# PLANNING BOARD REPORT PORTLAND, MAINE

Residential townhouse - 6 unit condominium  
133 York Street  
Level III Site Plan and Subdivision  
Project ID 2013-187  
133 York, LLC, Applicant

Submitted to: Portland Planning Board Public Hearing Date: November 12 <sup>th</sup> , 2013	Prepared by: Jean Fraser, Planner Date: November 8 <sup>th</sup> , 2013 <b>Planning Board Report # 50-13</b>
---	--

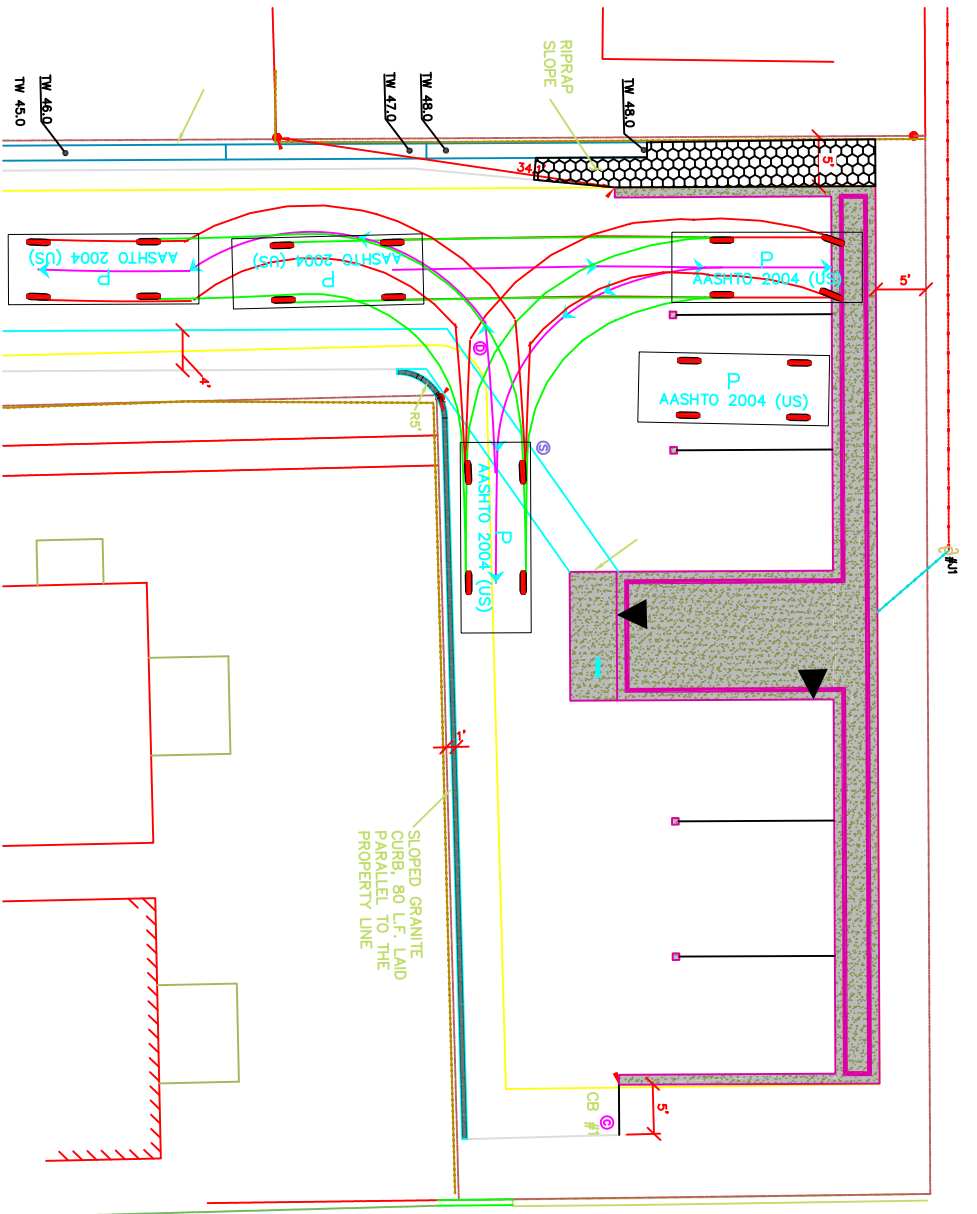
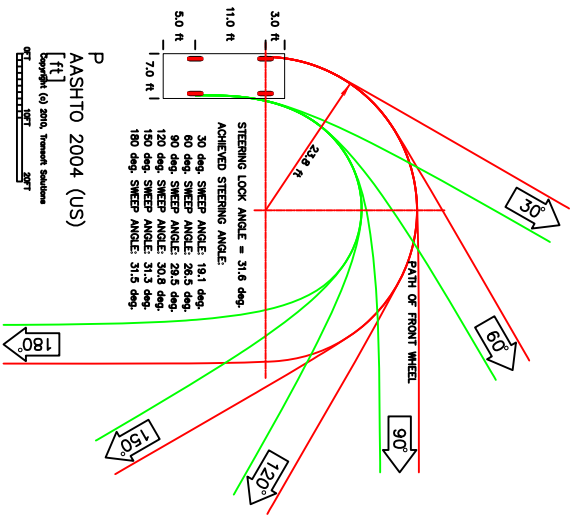
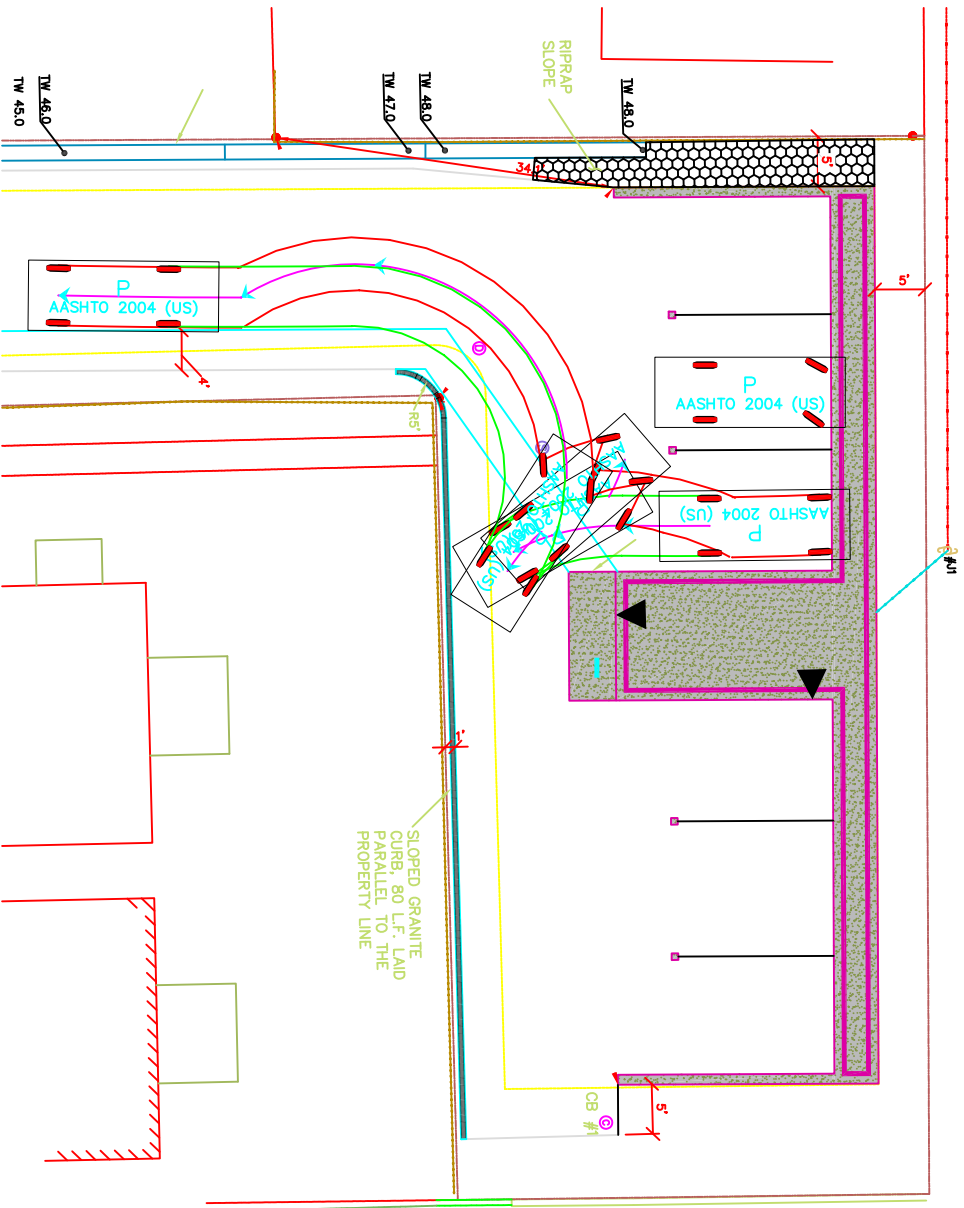
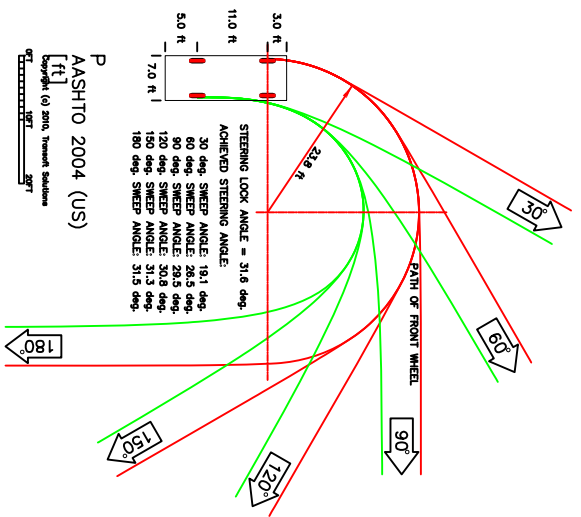
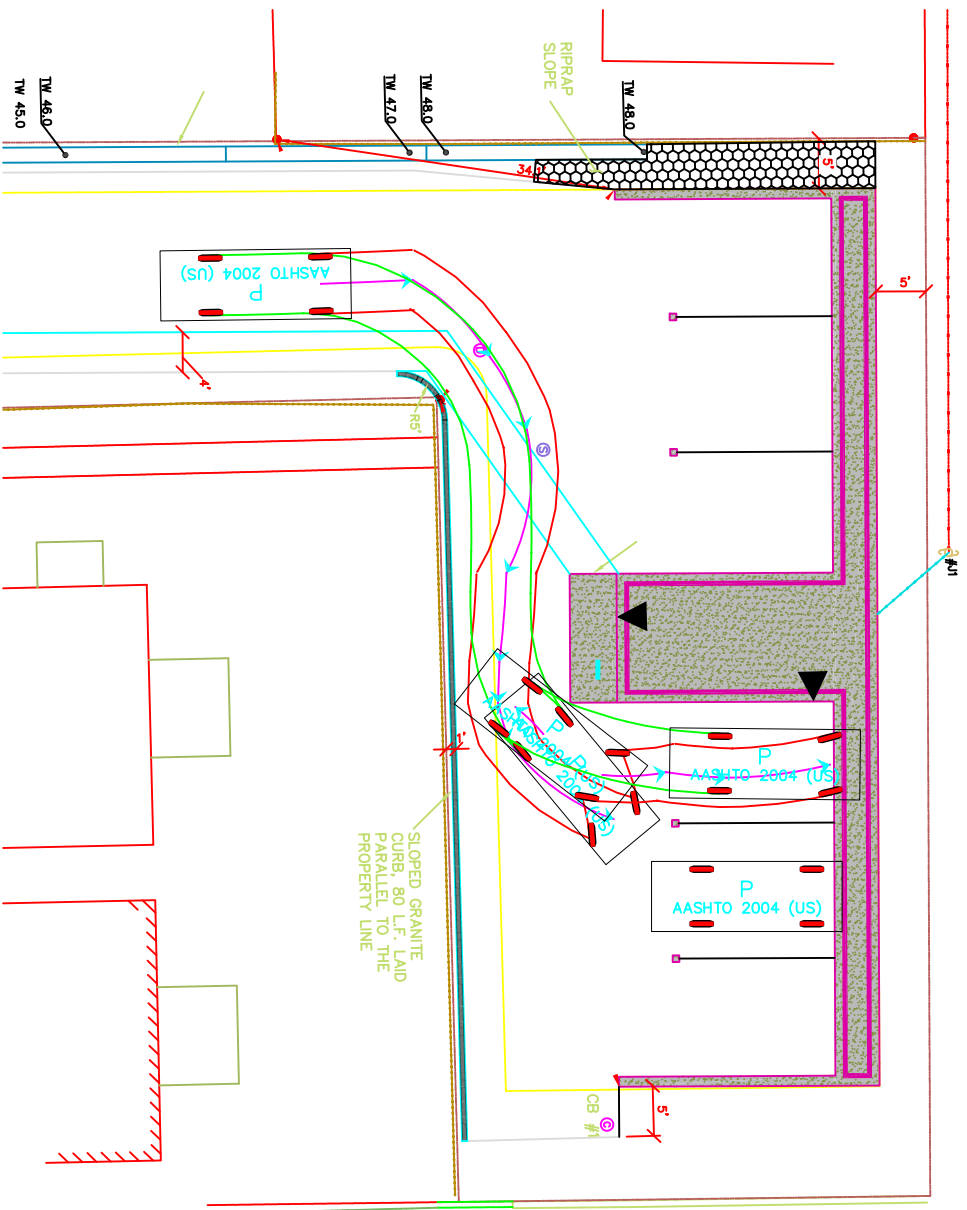
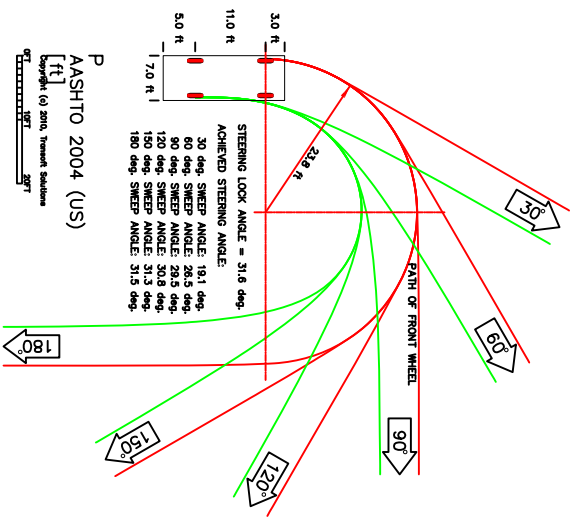
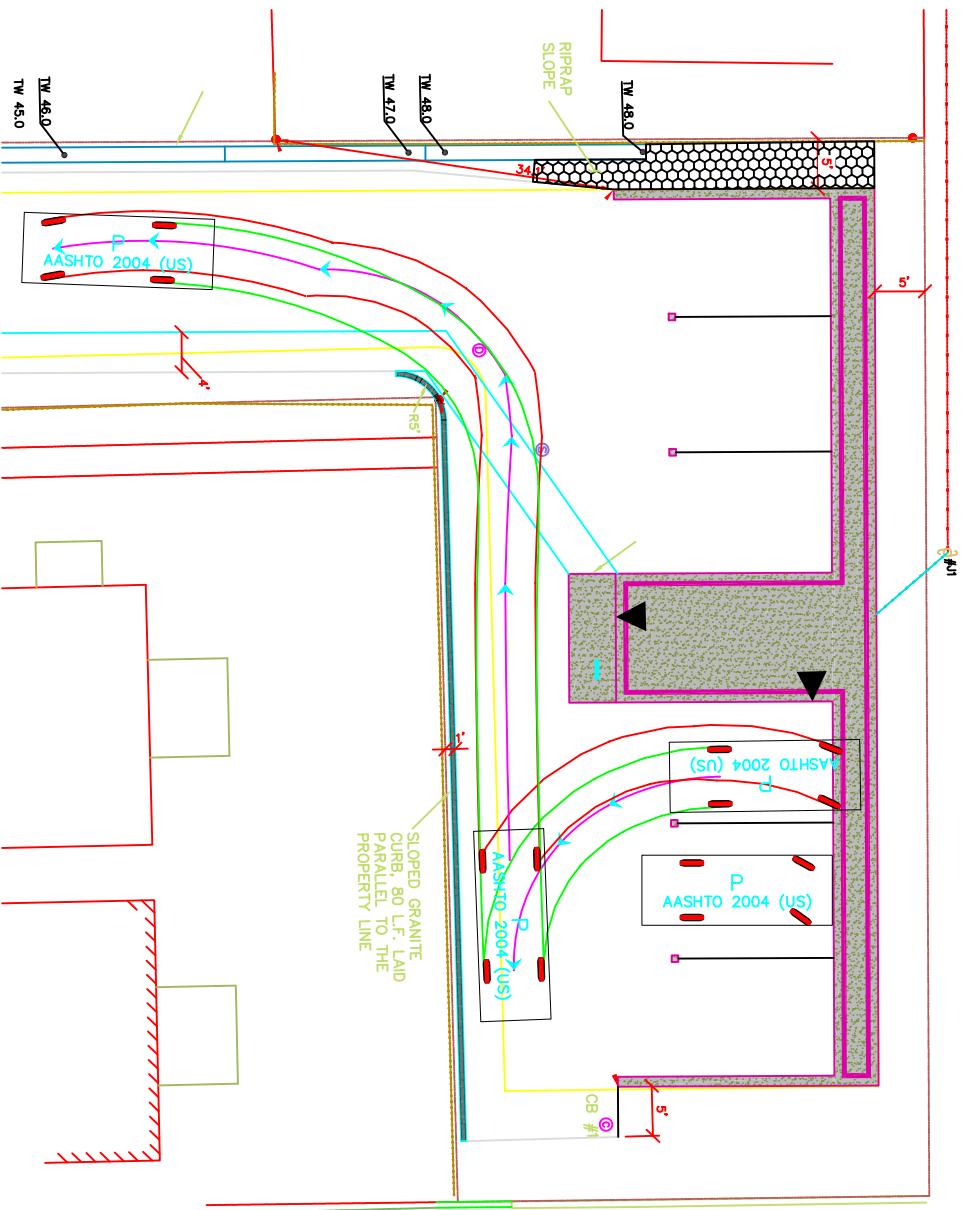
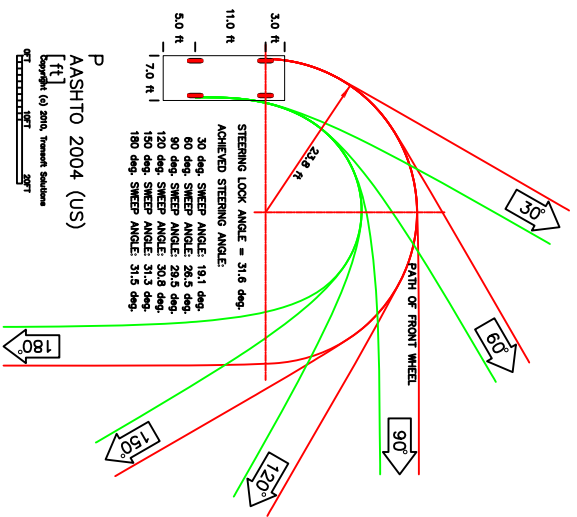
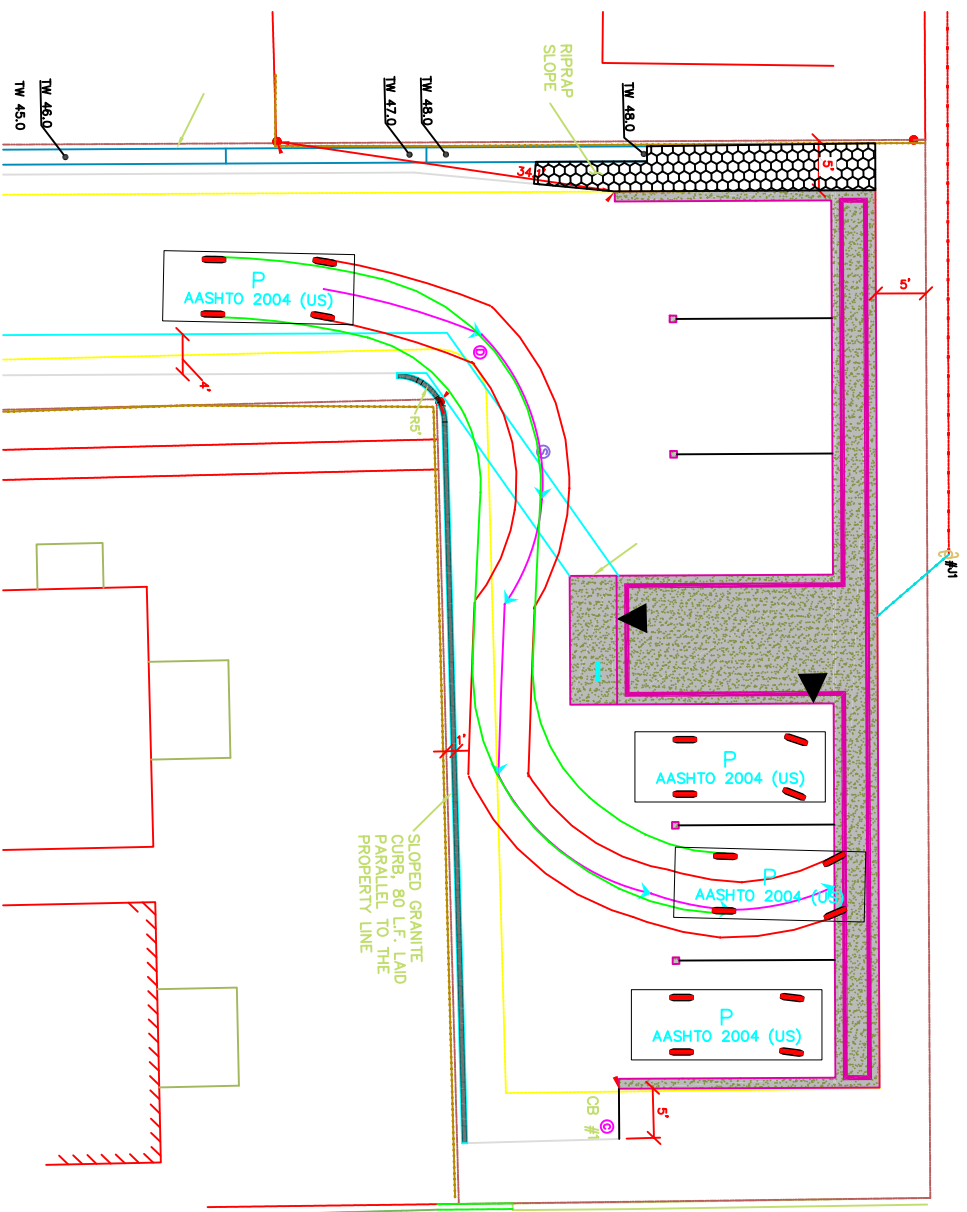
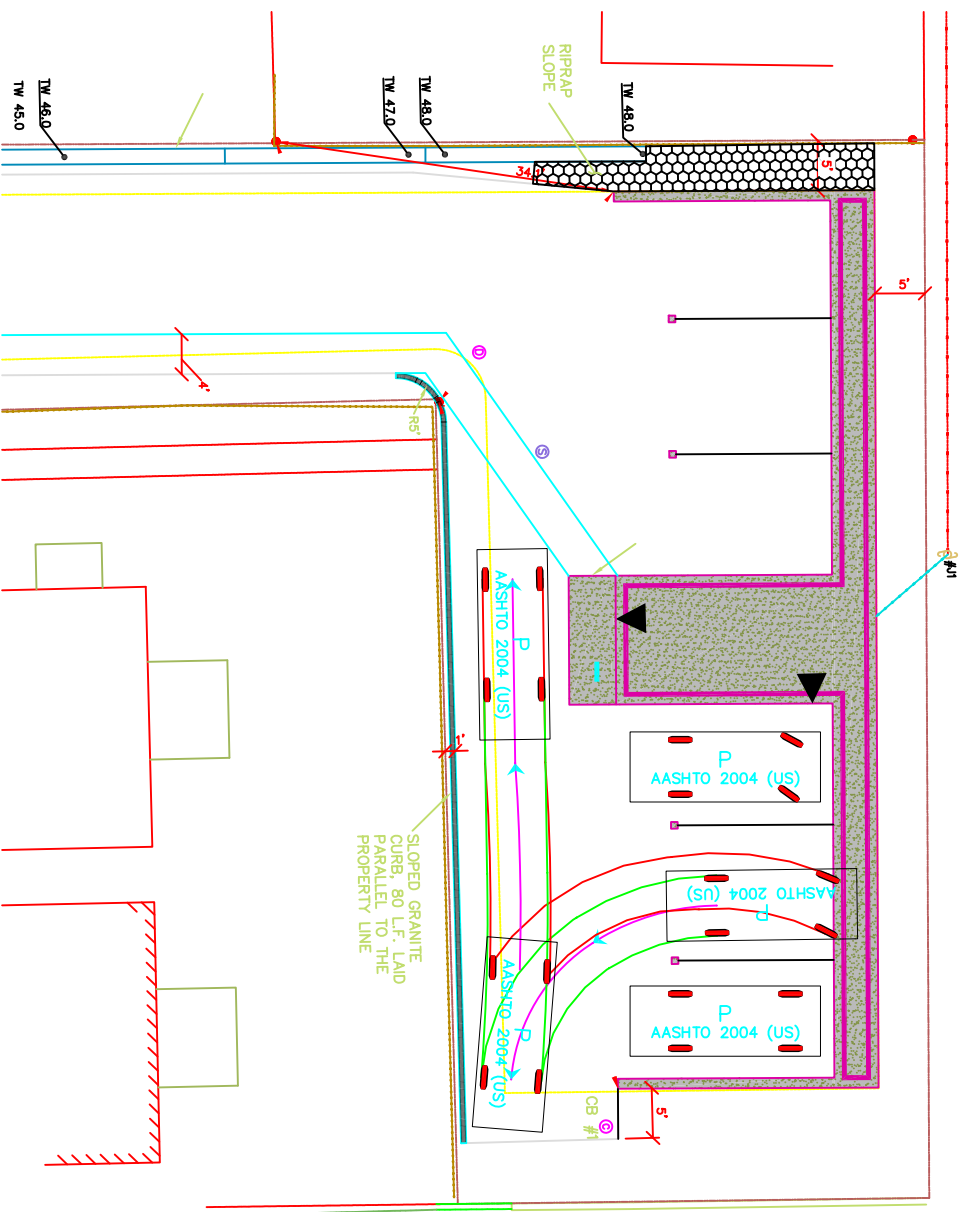
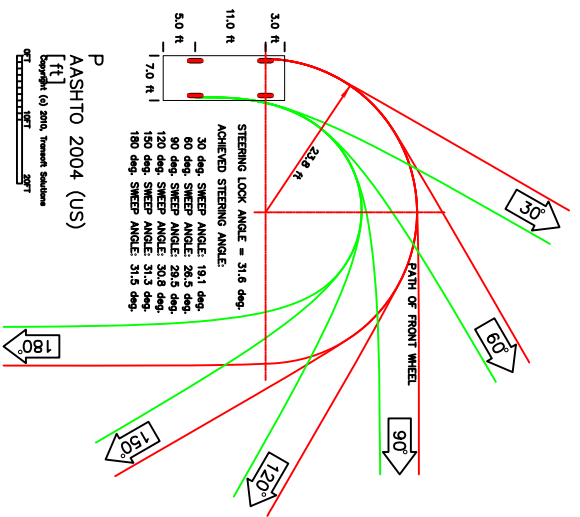
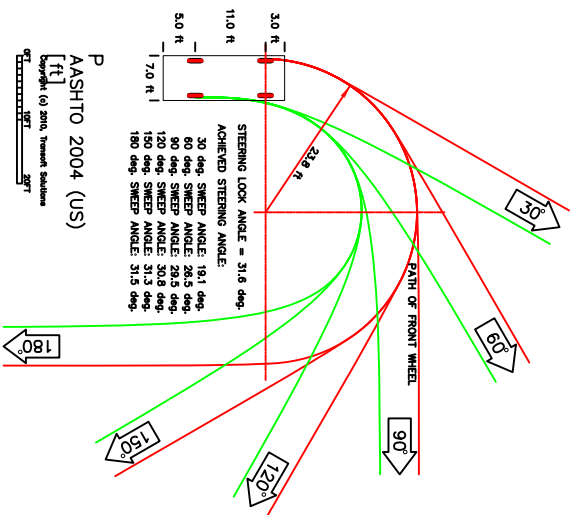
The size and placement of the building results in a narrow parking aisle leading to the 6 parking spaces located underneath the building. This potentially could cause congestion if the layout encouraged residents to back out of the drive onto York Street, which is heavily trafficked at this location near the bridge to South Portland. For this reason the Traffic Engineering Reviewer, Tom Errico, requested turning templates to illustrate the feasibility of access/maneuvering (Attachment 2). These were submitted and two of the parking spaces appeared

difficult to access (see [Attachment Y](#); an example is at right); Mr Errico wanted to confirm the adequacy of maneuvering space, as he has commented ([Attachment 14](#)):

- Access and egress movements into the garages appear difficult given the narrow pavement area. The applicant shall provide turning template graphics for a standard passenger car illustrating the ability of vehicles to adequately circulate on-site.

Status: The applicant has provided the requested turning template graphics. Given site constraints, I also requested that the applicant provide a simulated site layout in a parking area so that I could determine if vehicles could access/egress the parking garages. Based upon the field study, some garages will require multiple maneuvers (k-turns) to enter and exit the garages. The site is very constrained and the ease in which vehicles can make their intended maneuver will be a function of the design vehicle. My field simulation was based upon a Subaru station wagon and this represents a mid-size vehicle. Large Single-Unit Vehicles (SUV) will have greater difficulty.

With all that said, I do support a waiver from our technical standards for parking lot aisle width dimensions. The waiver is suggested given the unlikelihood that vehicles will back down the driveway into York Street. There is a significant distance between the garages and York Street, and thus feel that all maneuvers will occur on-site. I would note that the bicycle rack should be relocated so that it does not impede circulation. Additionally, it will be very important that snow removal/maintenance is effective so that snow does not further constrain the site.
